WEST SUSSEX COUNTY COUNCIL CONSULTATION

TO:	Arun District Council FAO: James Cross
FROM:	WSCC - Highways Authority
DATE:	2 December 2019
LOCATION:	2 Cavendish Road, Bognor Regis, PO21 2JW
SUBJECT:	BR/256/19/PL Conversion of existing store to 2 bed dwelling to the rear of 2 Cavendish Road, fronting Sutherland Close.
DATE OF SITE VISIT:	N/A
RECOMMENDATION:	Advice
S106 CONTRIBUTION TOTAL:	N/A

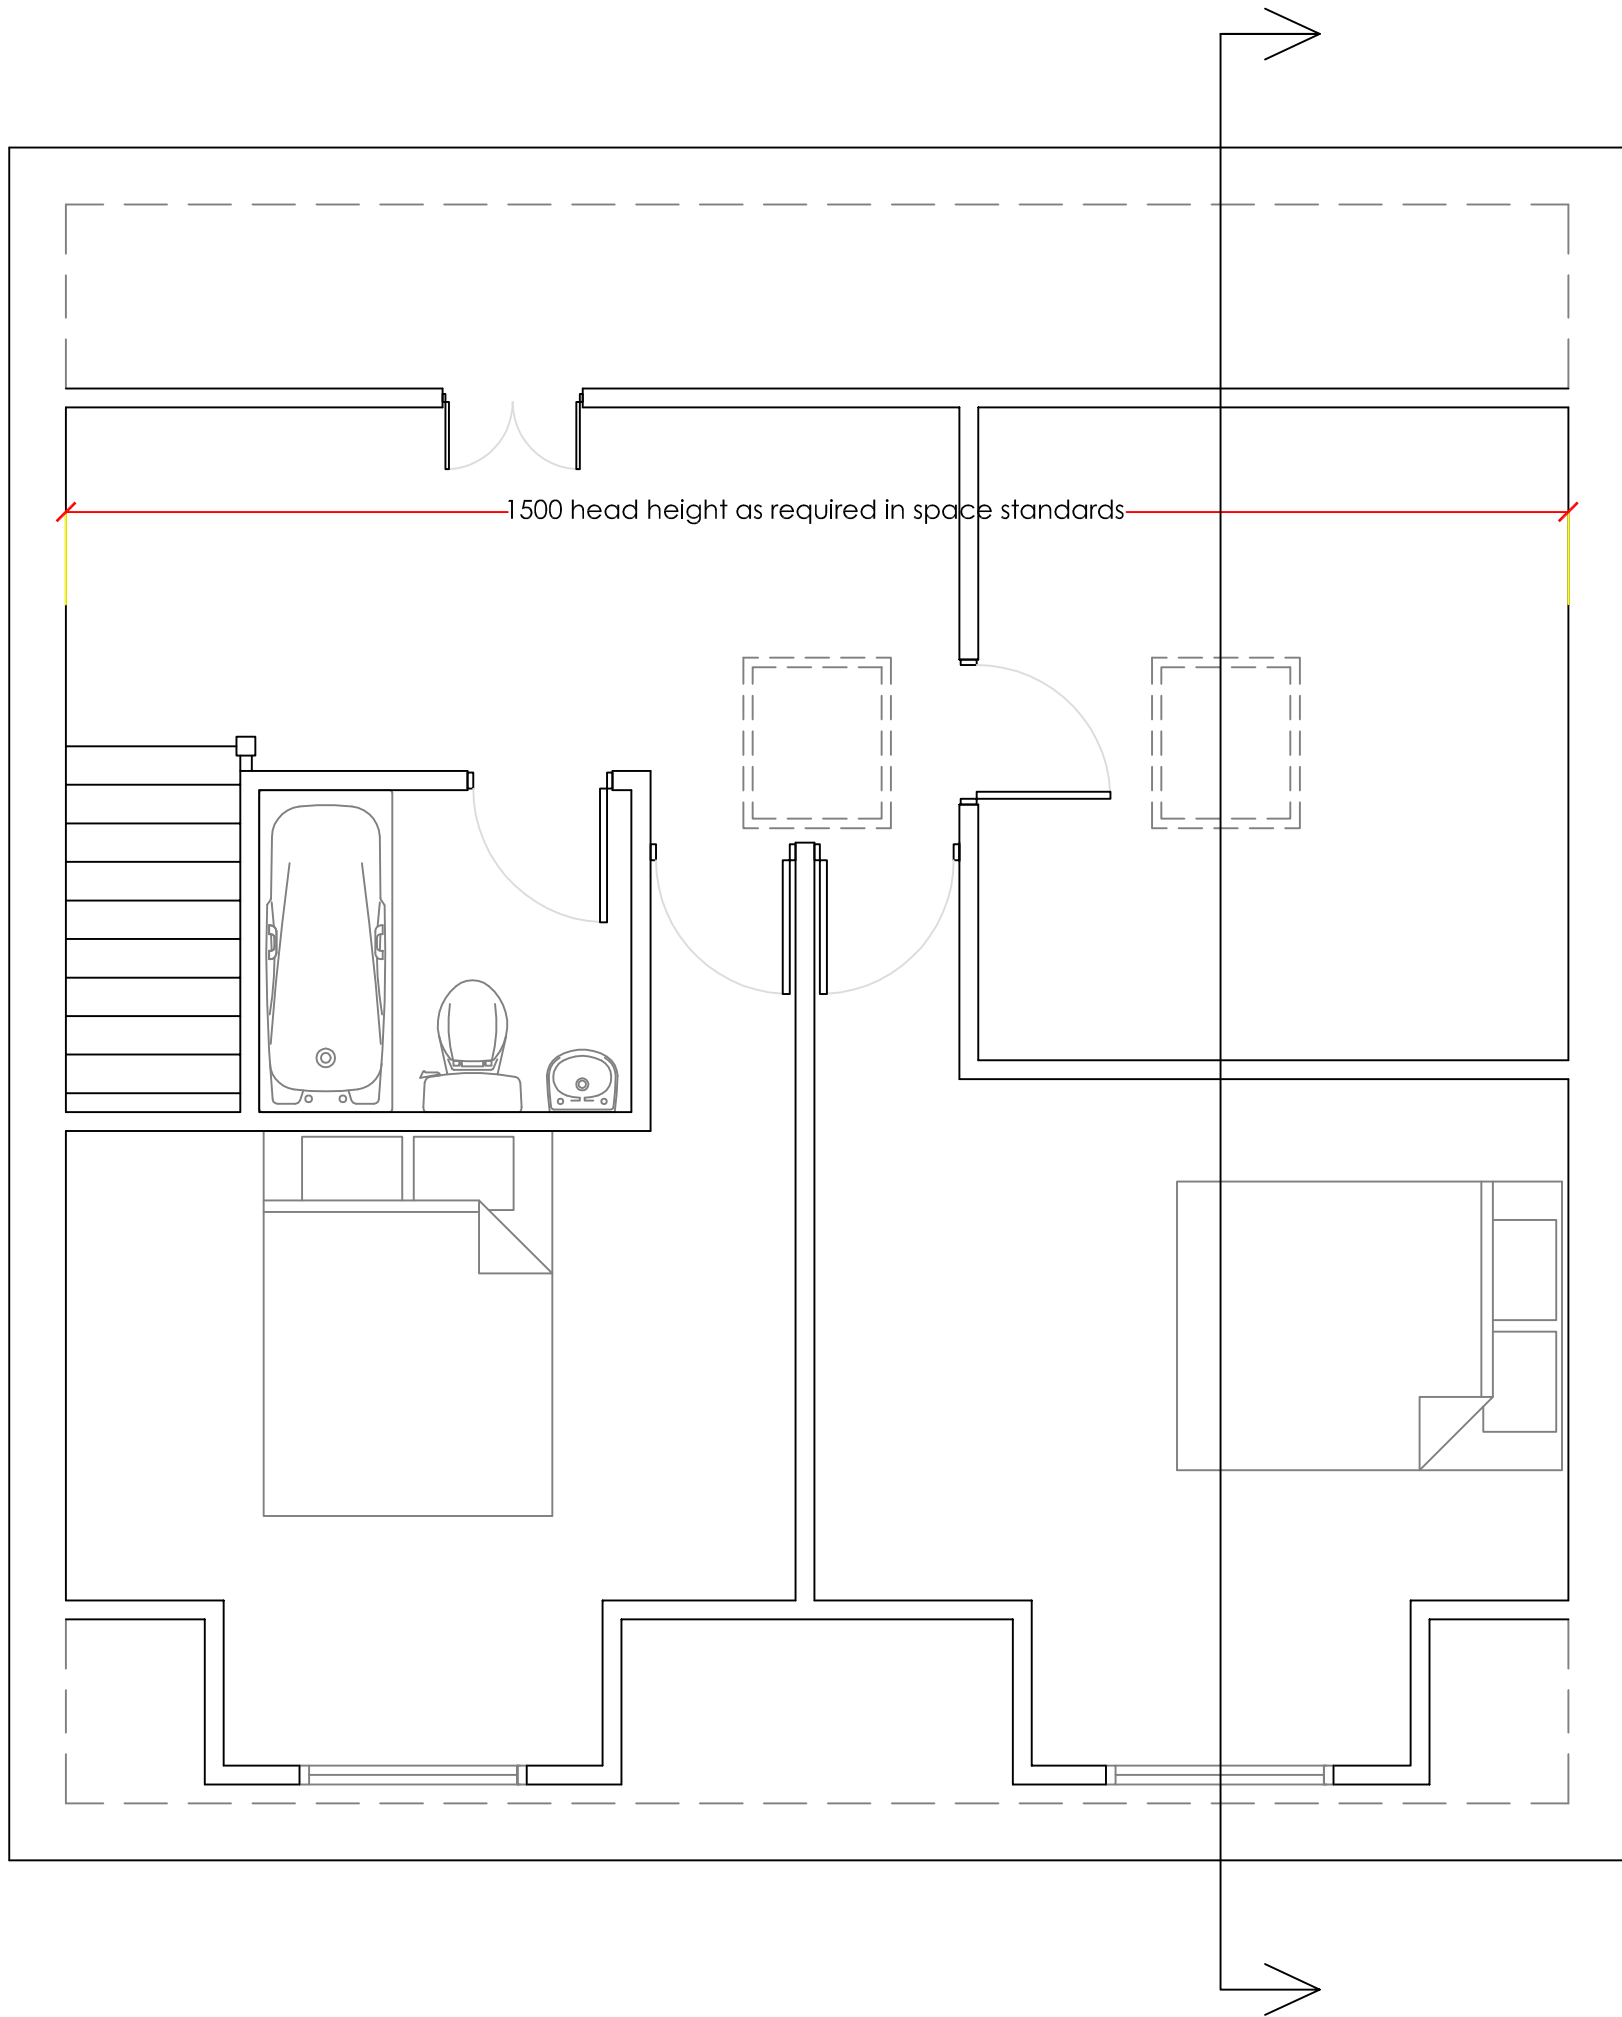
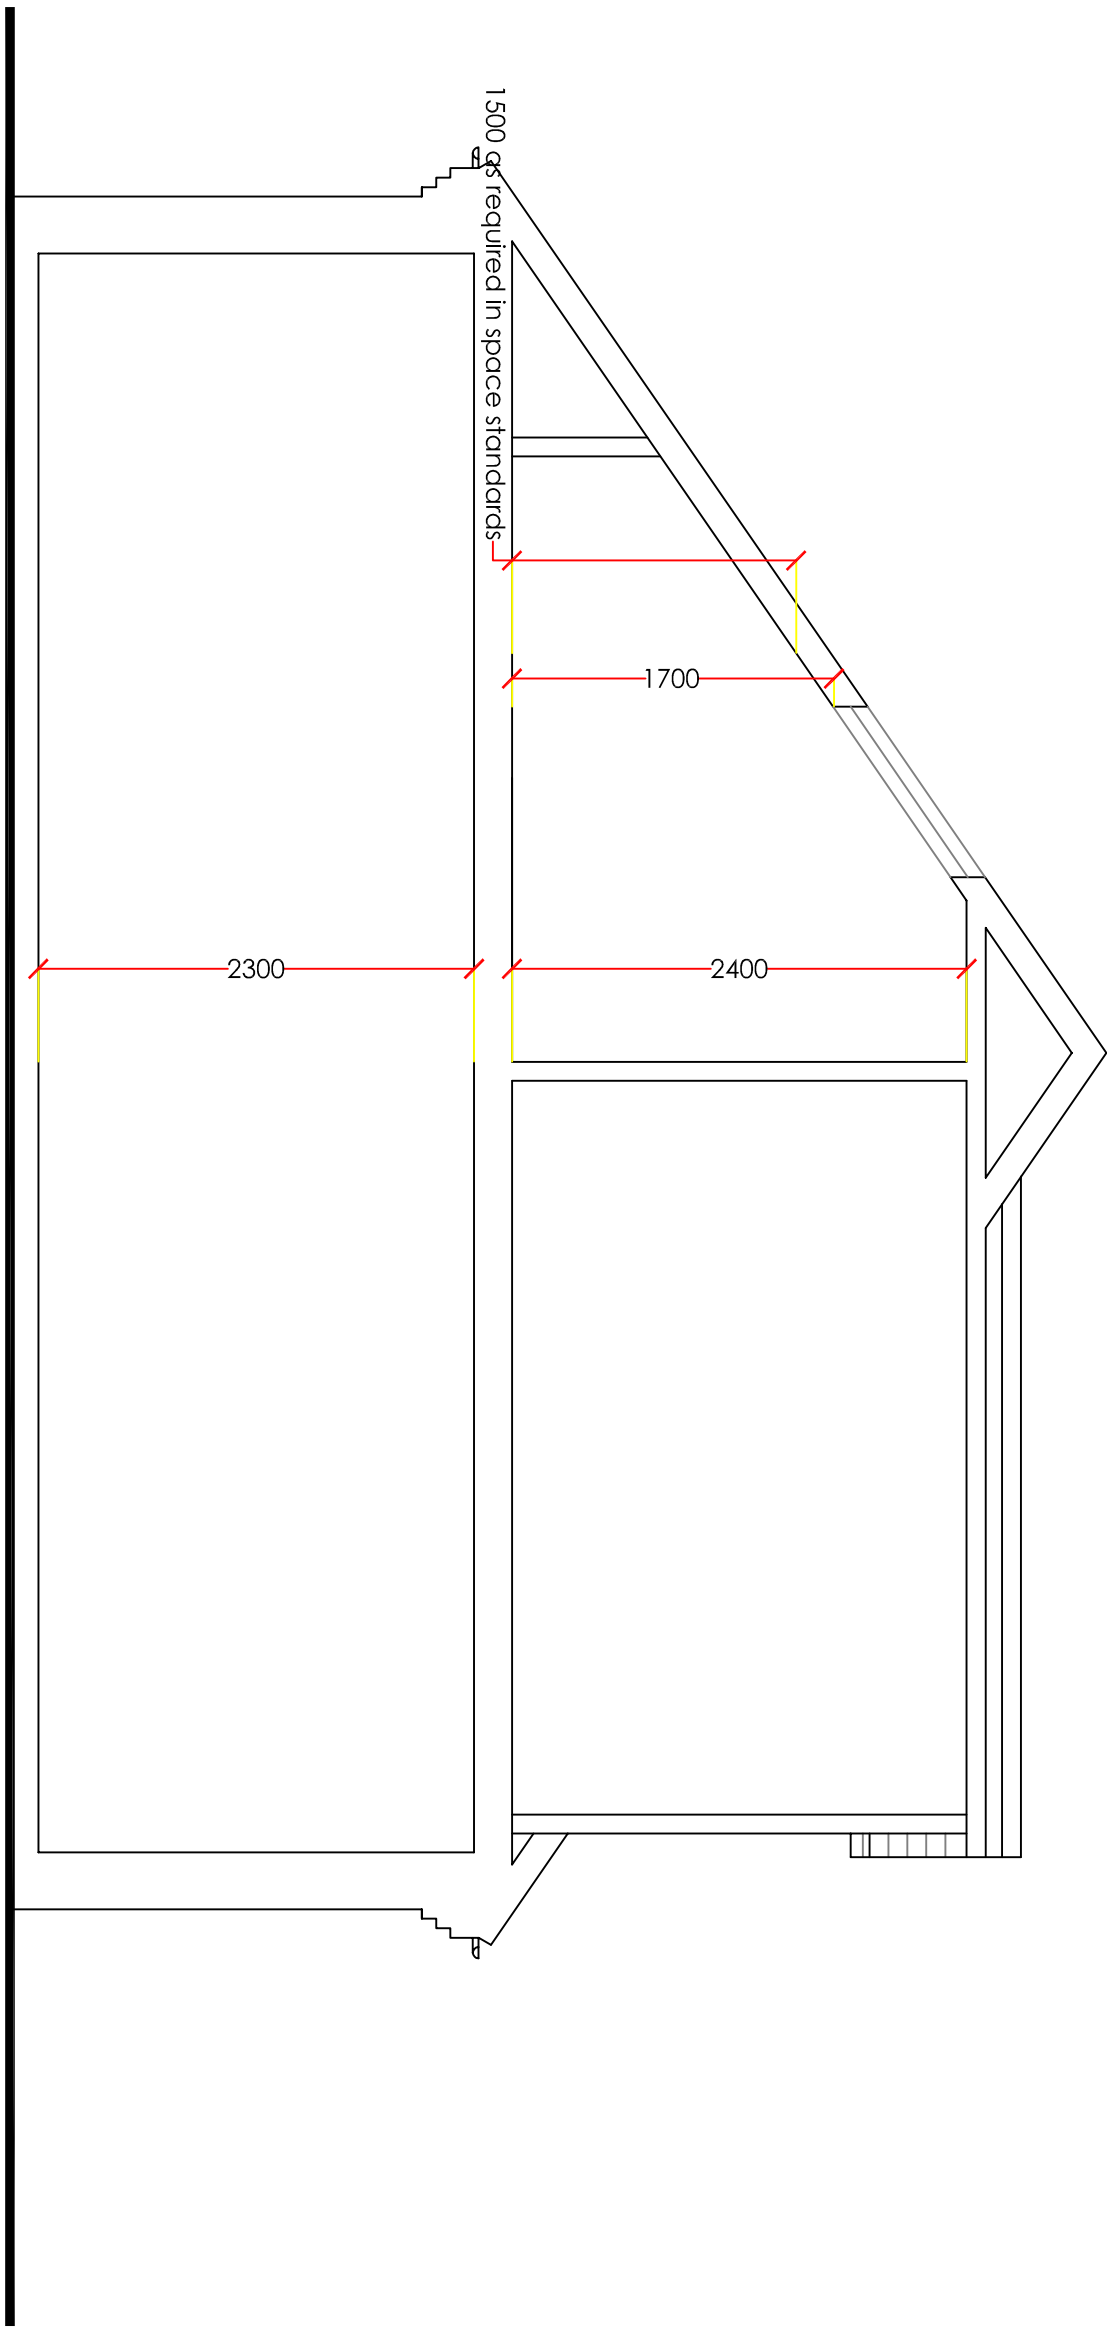
The existing access via Sutherland Close will be utilised. There is an existing dropped kerb to the front of the property. To avoid potential conflict with the kerb, the applicant is advised to have the existing dropped kerb widened. This would be subject to a licence and would be constructed to a specification agreed with the local area engineer.

The applicant is advised that in addition to obtaining planning permission that they must also obtain formal approval from the highway authority to carry out the site access works on the public highway. The granting of planning permission does not guarantee that a vehicle crossover licence shall be granted.

Proposed South Elevation

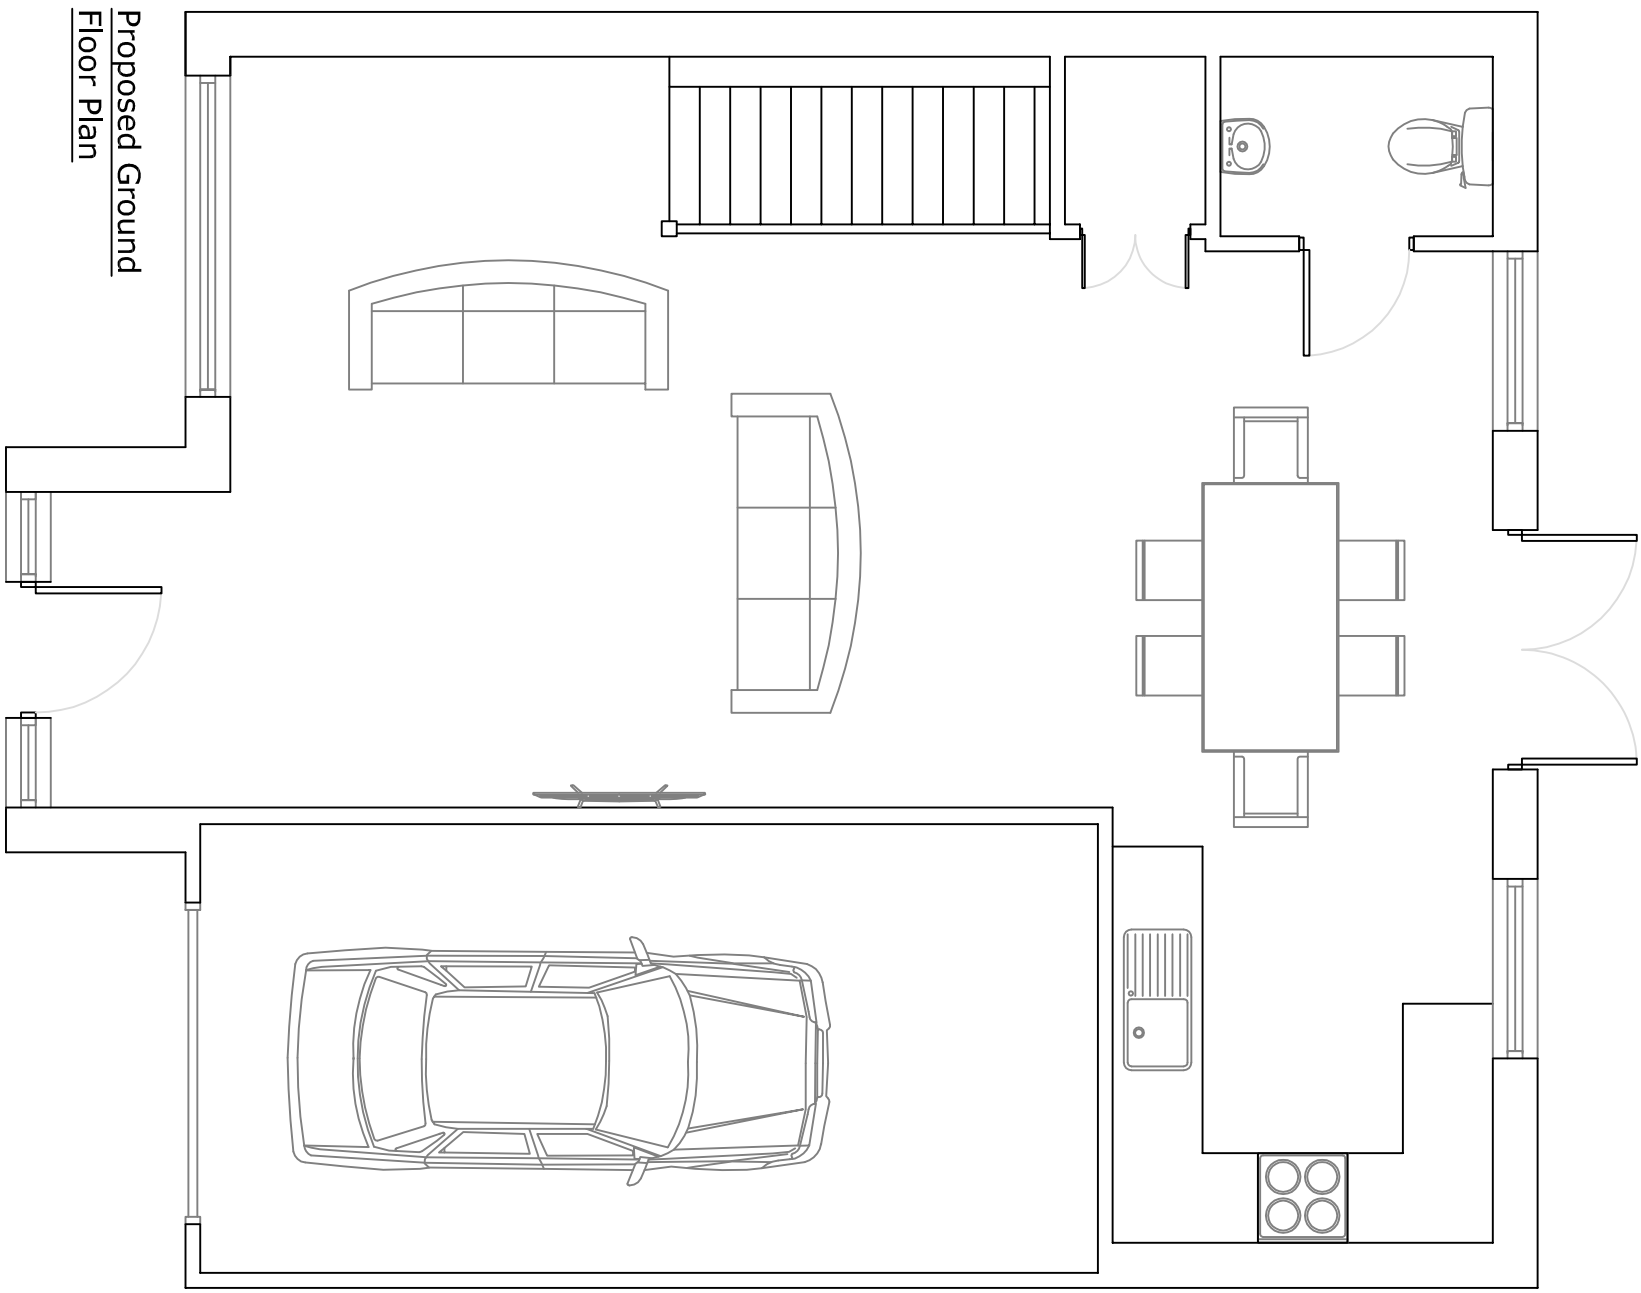
A single car garage is proposed for the dwelling. The garage demonstrated in the plans has approximate internal dimensions of 3m x 6m. This meets the minimum internal specifications for single car garages as set out in Manual for Streets (MfS). The garage can therefore be considered for parking provision for 1 car.

In terms of cycle parking, a cycle store to the rear of the plot has been demonstrated. The garage can also be utilised for the storage of cycles. Under WSCC parking standards, a dwelling of this size should provide secure and covered cycle parking for at least 1 cycle. The inclusion of cycle parking helps promote the use of sustainable alternative modes of transport to the private car.

On-site turning does not appear to be achievable, so vehicles may have to exit the site in a reverse gear. However, Sutherland Close has good forward visibility and neighbouring properties appear to operate similar arrangements with no known safety concerns.

No part of the development shall be first occupied until covered and secure cycle parking spaces have been provided in accordance with plans and details submitted to and approved by the Local Planning Authority.

No part of the development shall be first occupied until the car parking has been constructed in accordance with the approved site plan. These spaces shall thereafter be retained at all times for their designated purpose.
